State of Washington
DEPARTMENT OF FISH AND WILDLIFE

April 9, 2024

**SUBJECT: WDFW COMMENTS ON RU-24-00001 HORISH REASONABLE USE SV-23-00001
HORISH SHORELINE VARIANCE**

Figure 1: This image comes from Page 9 of the Critical Areas Report submitted with the Horish Reasonable Use application. It clearly shows Wetland D in direct connectivity with the OHWM of a Type S water near the bottom right of this image.

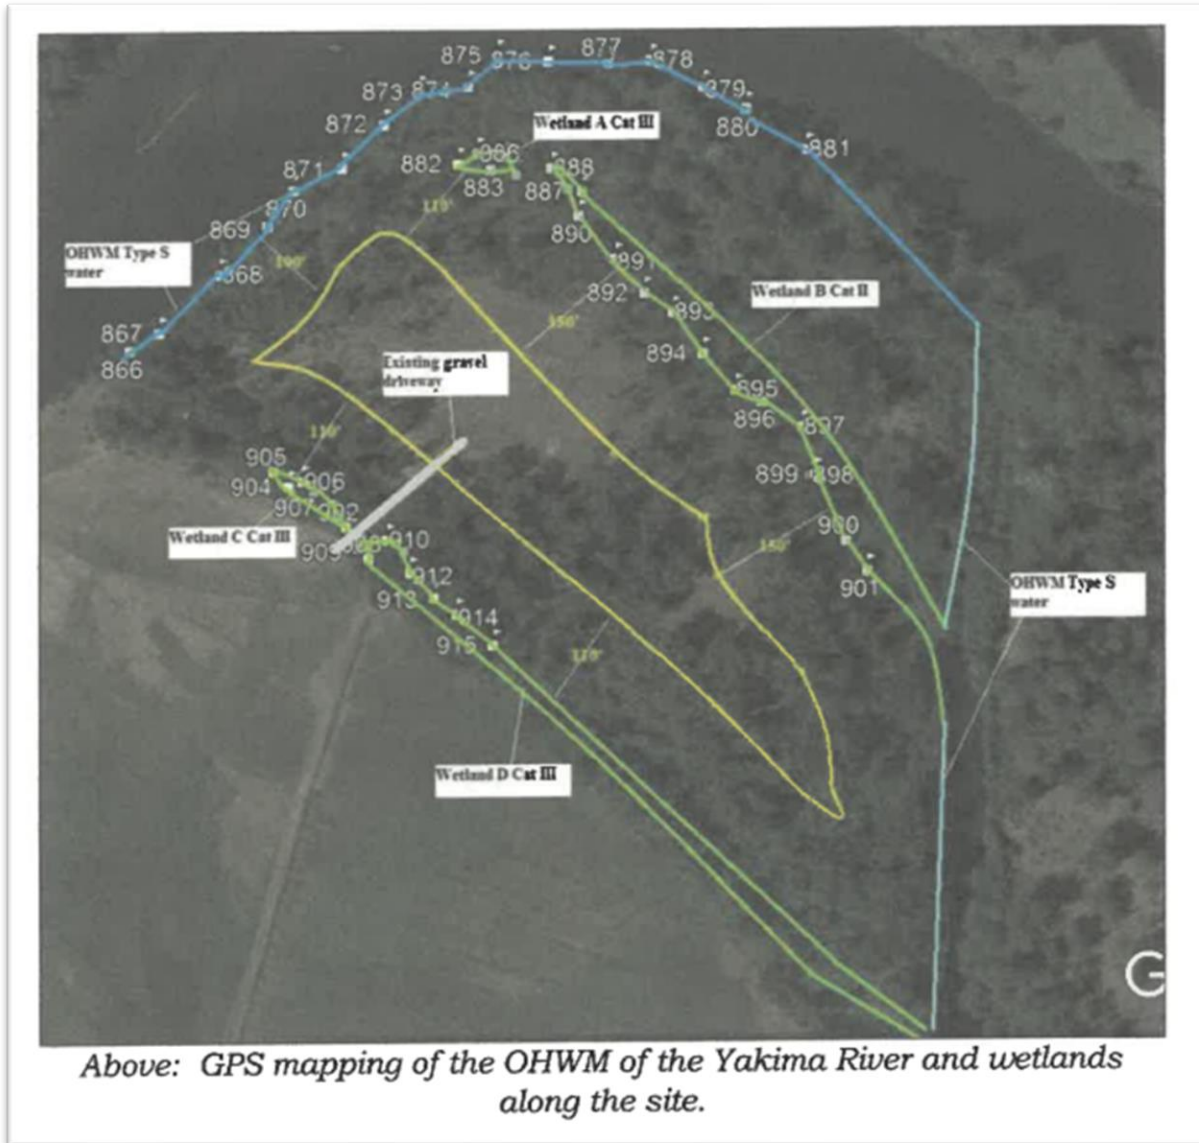
The Kittitas County Code 17B.01.020 defines the scope and jurisdiction of Shorelines in Kittitas County to include "*all shorelines of the state; upland areas (shorelands) within two hundred (200) feet of the ordinary high water mark of those waters; associated wetlands and river deltas; and floodways and contiguous floodplain areas landward two hundred (200) feet from such floodways.*" The wetlands identified in the critical areas report are directly associated with the Yakima River, a shoreline of statewide significance, and are subject to the Shoreline Master Program. The figure on page 9 of the [Critical Area Report](#) shows Wetland D terminating at the Ordinary High Water Mark of a Type S Water, a side channel of the mainstem Yakima River (Figure 1).

We do not dispute that Wetlands C and D are likely influenced by irrigation practices on the pasture south of them, but they are also hydraulically connected to the mainstem Yakima River as they are relic channel scars within the channel migration zone. These wetlands provide important fish and wildlife habitat as they are directly connected to the Yakima River, just east of the areas shown in the Critical Areas report (Figure 2).

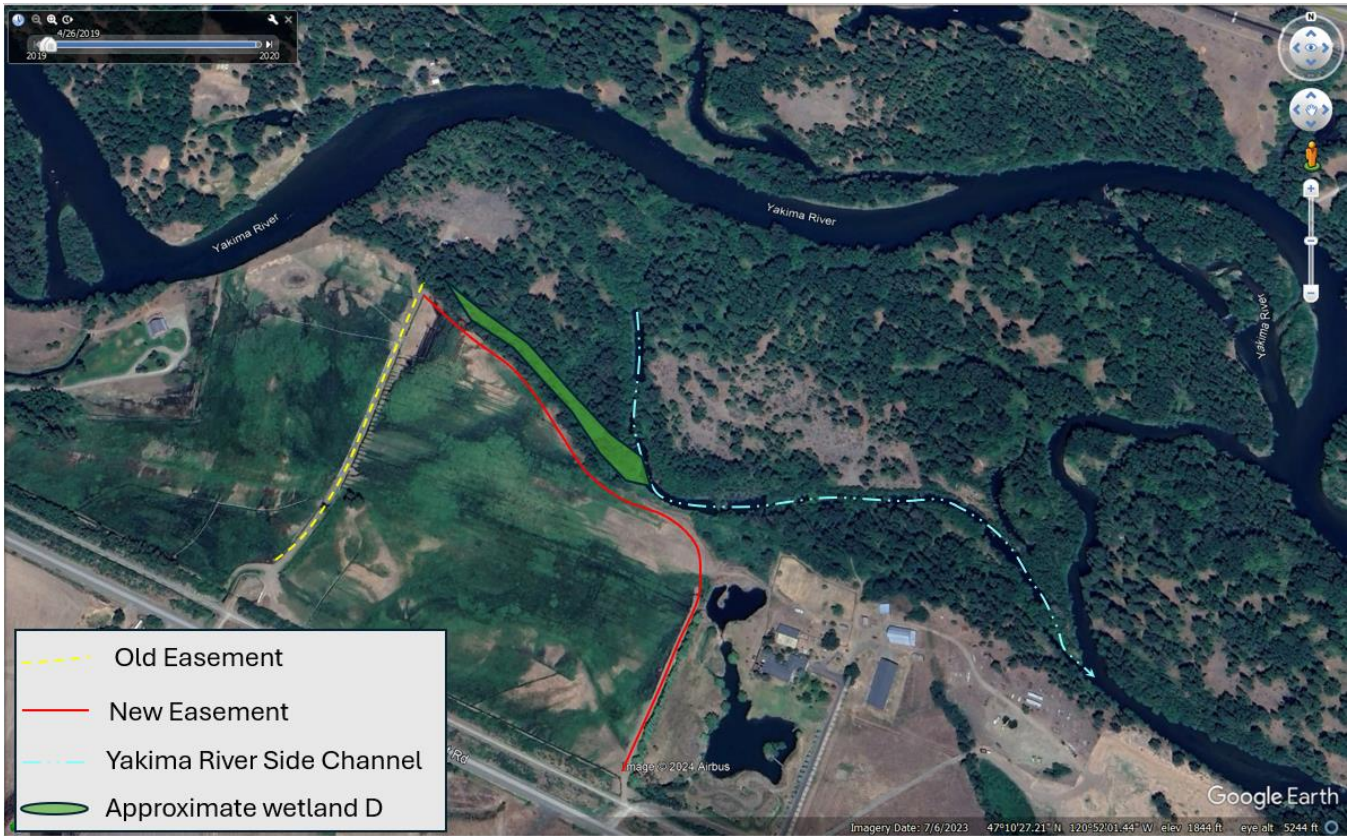
It is our understanding that Ms. Horish recently willingly relocated the existing easement across parcel 546534 to access parcel 516534. The new easement location results in the need for a new driveway that follows the terrace edge of the Yakima River floodplain and its associated side channels and wetlands; thereby creating a need for additional mitigation and potential variances from existing code. The proposed driveway falls within the buffer requirements for the Shoreline Master Program (KCC 17B) as the wetlands are in direct connectivity with side channels of the Yakima River. **The Reasonable Use considerations under the Critical Areas Code (KCC 17A) are helpful for considering impacts, but KCC 17A is not applicable in this location for this project and we recommend reconsideration of the Shoreline Variance as originally proposed.**
